### Application for Removal or Variation of a Condition following Grant of Planning Permission or Listed Building Consent

Demolition of garden room and erection of a two storey rear extension, fenestration alterations and replacement garage

23/01350/HOU

condition 2 - approved drawing changed from 2359/05B to 2359/05E.

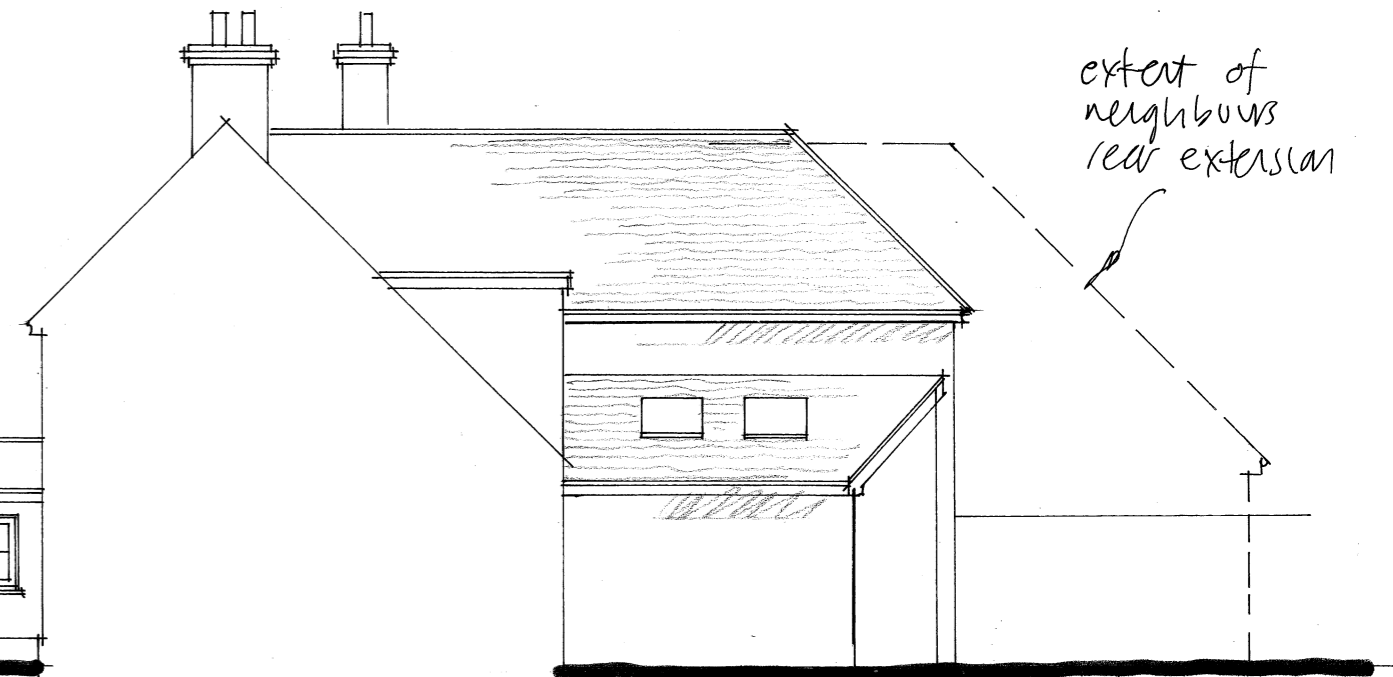
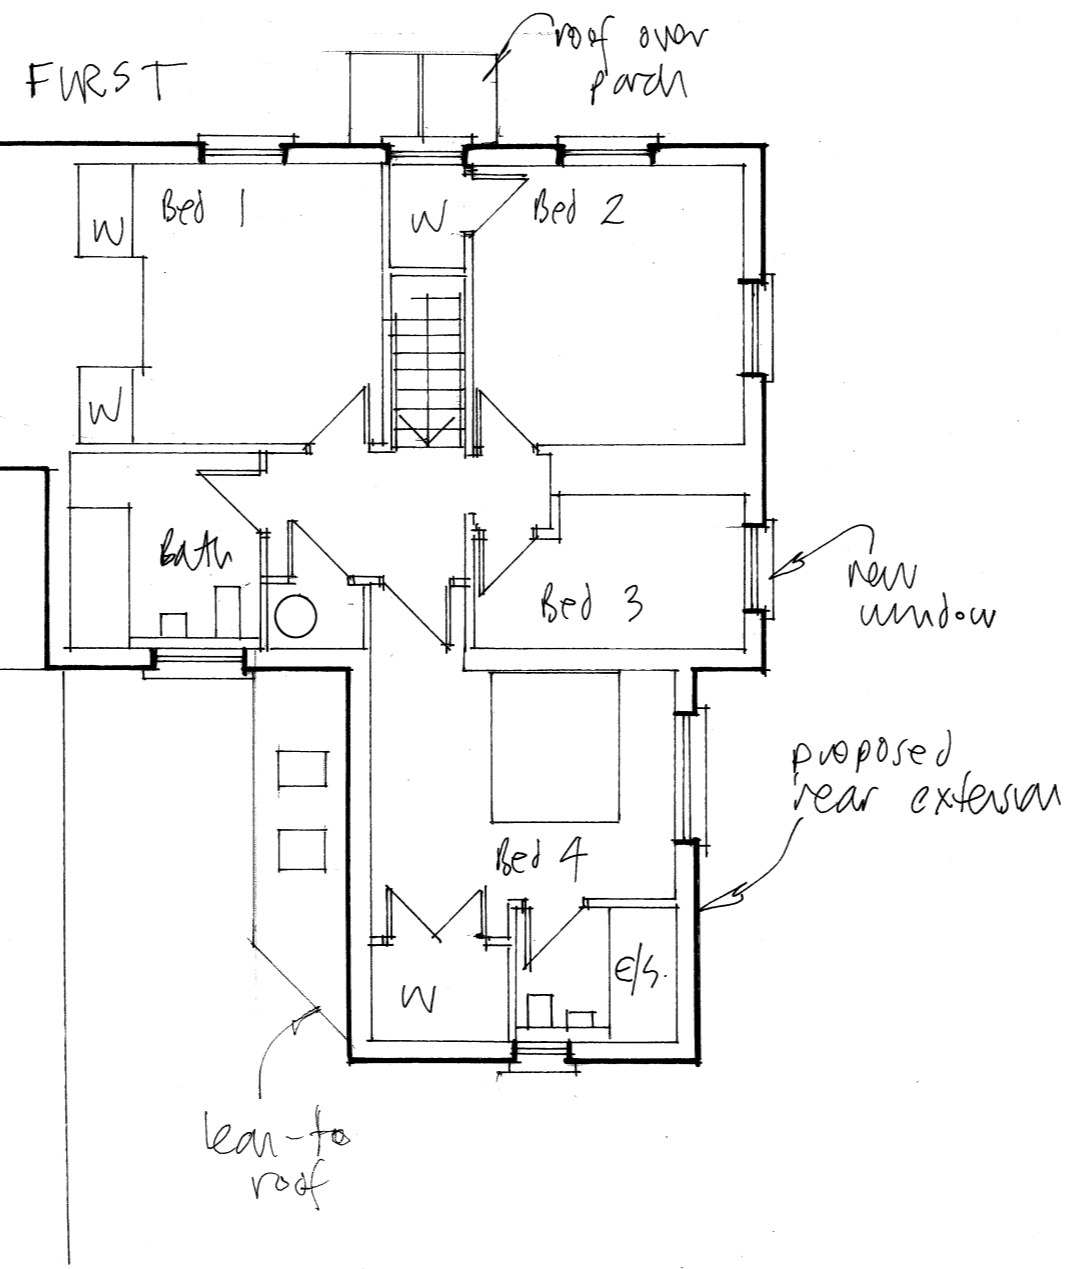
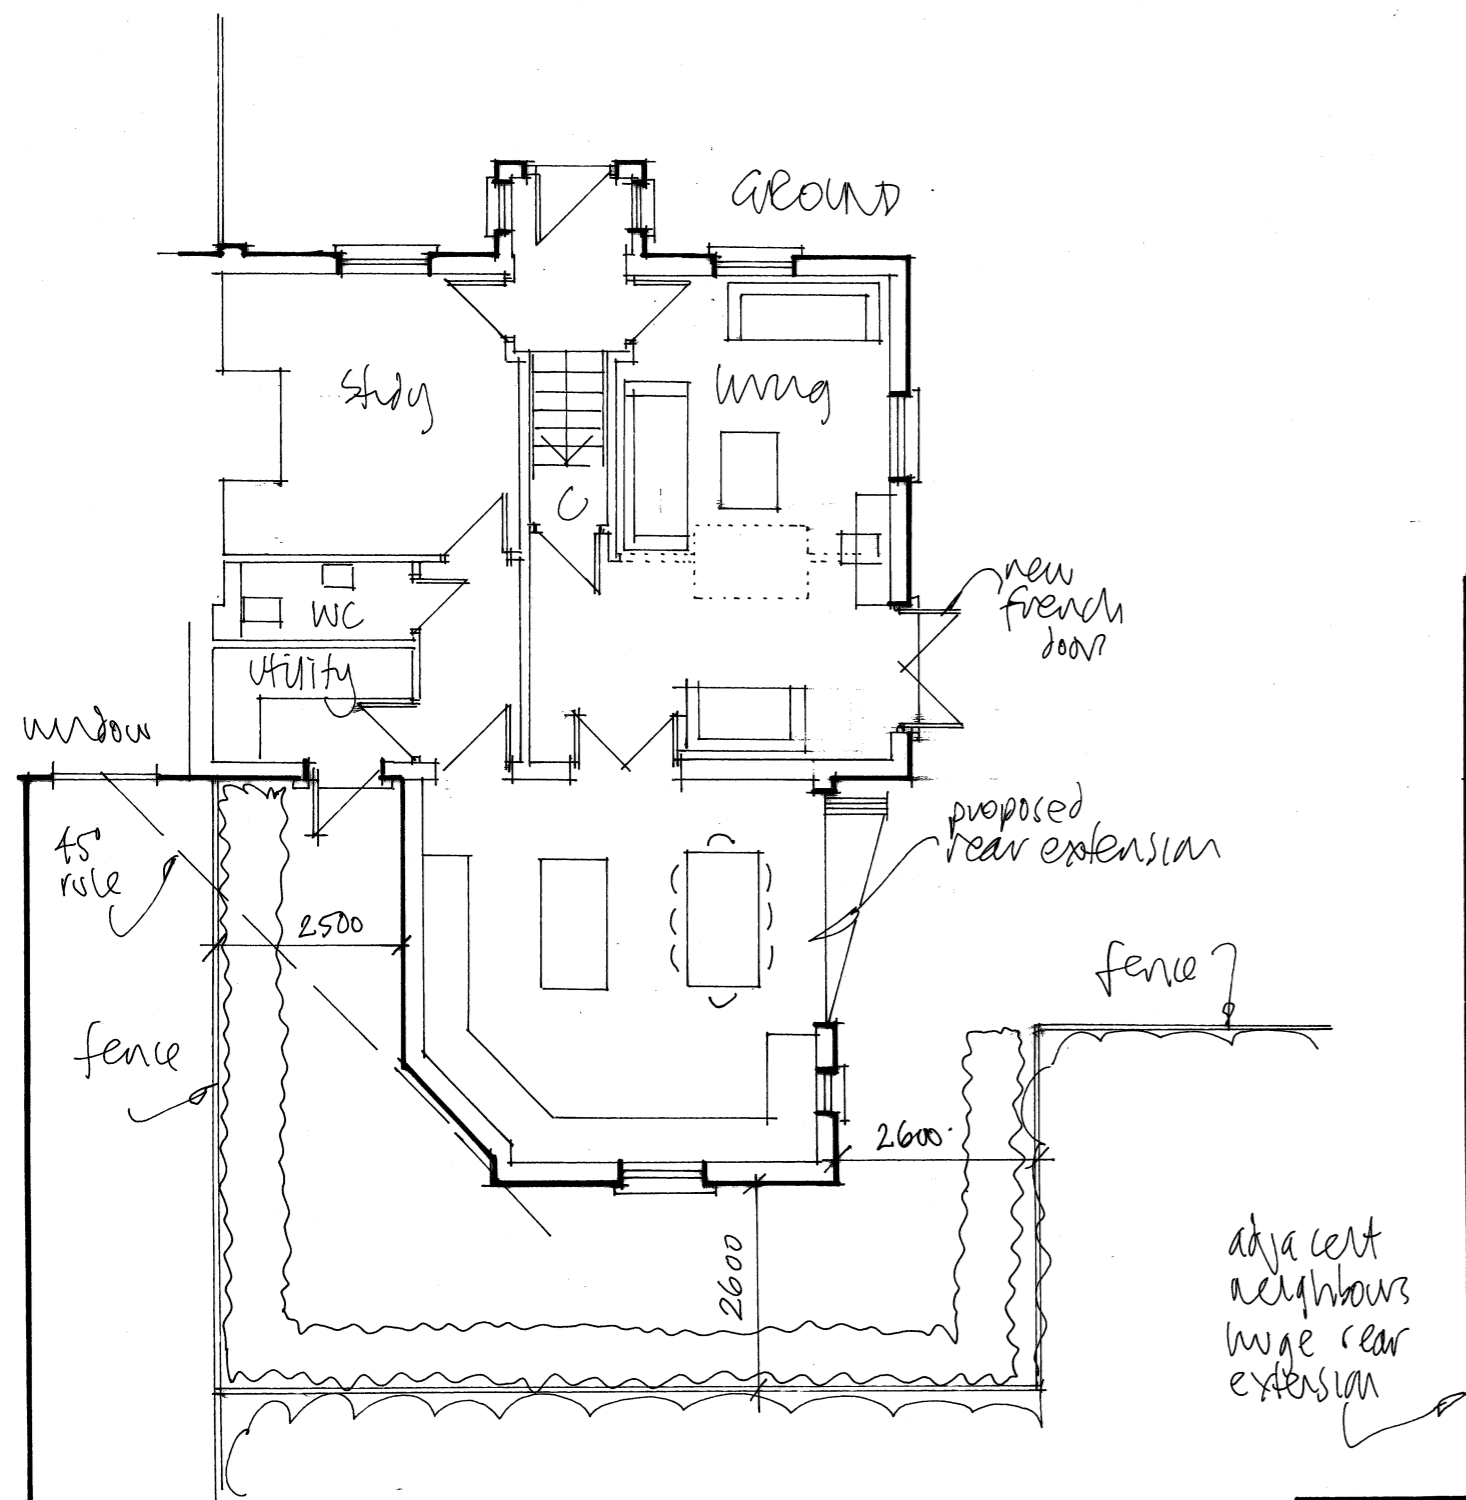
The existing small leaking flat roof will be changed to a tiled hipped roof - this will improve the aesthetics of the scheme and avoid a long term maintenance issue with the flat roof.

The french doors and bi fold doors on the side elevation to be changed to aluminium (anthracite colour). This is to keep the sections slim and to use a better thermally efficient system.

condition 3 - material condition to also include wording that side elevation french doors and bi-fold doors to be anthracite coloured slim section aluminium system.
